**Application Reference: 2025/0872**

**Site Address: 25 Low Folds, Monk Bretton, Barnsley, S71 5SB**

This application seeks full planning permission for the erection of a side detached garage/garden room.

**SITE PLAN SCALE 1:500**

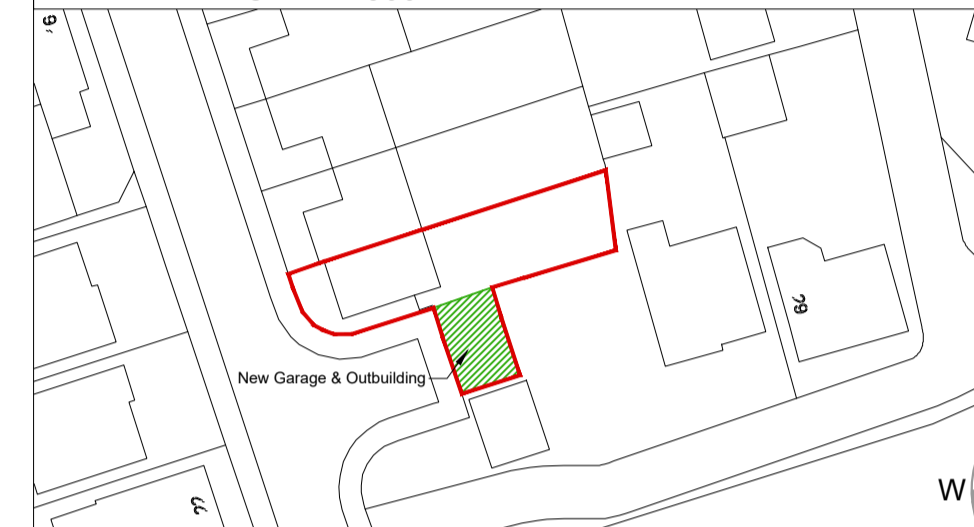
The proposed garage would be sited at the back edge of the footway and is not large enough to fit even a single conventional car, in a location where the Parking SPD requires a minimum of 2 parking spaces. This means that residents are likely to be obliged to park on the highway, in a location where parking on the turning head would cause an obstruction to users of the turning head, particularly to service vehicles /HGVs /bin lorries.

The proposed garage does not meet the requisite minimum set back from the highway or minimum size of a functional garage to accommodate a conventional car. The proposal therefore would result in the loss of two existing parking spaces, with parked vehicles likely to be displaced onto the adjacent highway and turning head. Such displacement would obstruct essential manoeuvring space and for all including service and emergency vehicles, compromising the safe and efficient operation of the highway contrary to Local Plan Policy T3 New Development and Sustainable Travel, the Parking SPD and NPPF paragraph 116.

**Proposed Plan**  
Scale 1:20

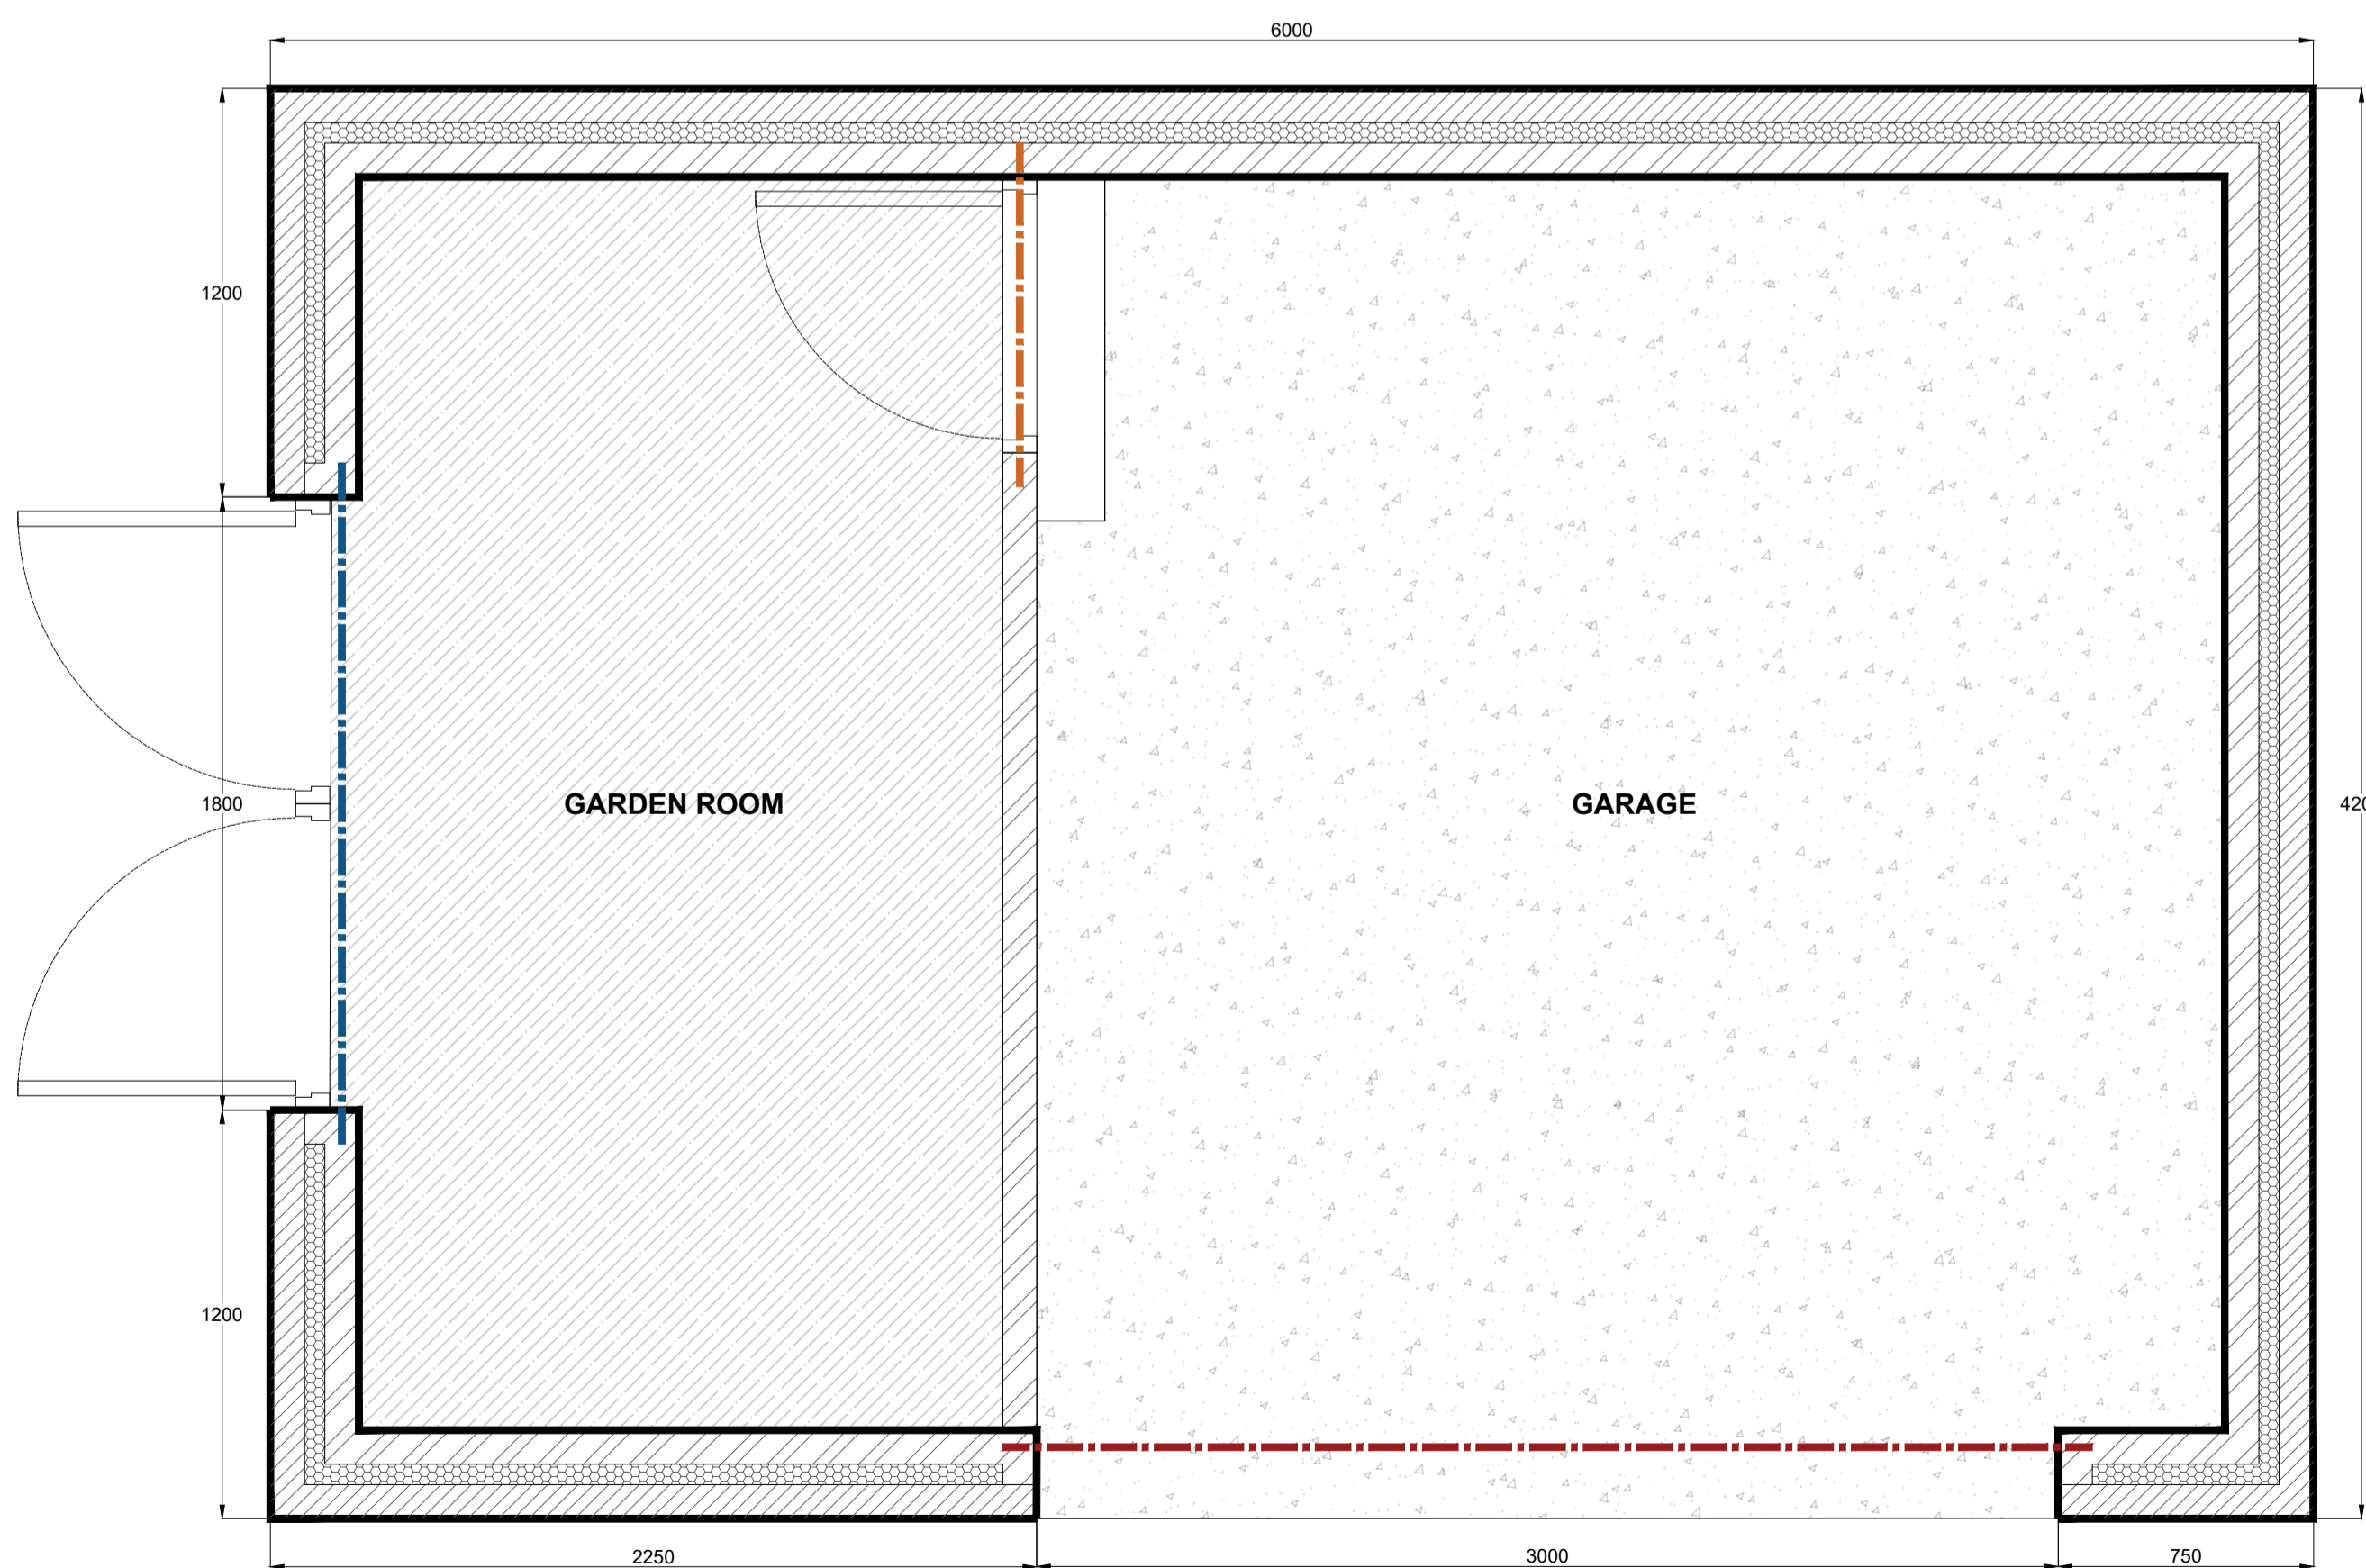
The application proposes to build a detached garden room/garage with bricks and tiles to match those used in the existing house. The proposed building is 6 metres wide and 4.2 metres deep, with the garage element measuring (internally) 3.5 metres wide by 3.7 metres deep. The building would be sited at the back edge of the footway and is 2.5 metres to eaves and 4 metres to ridge.
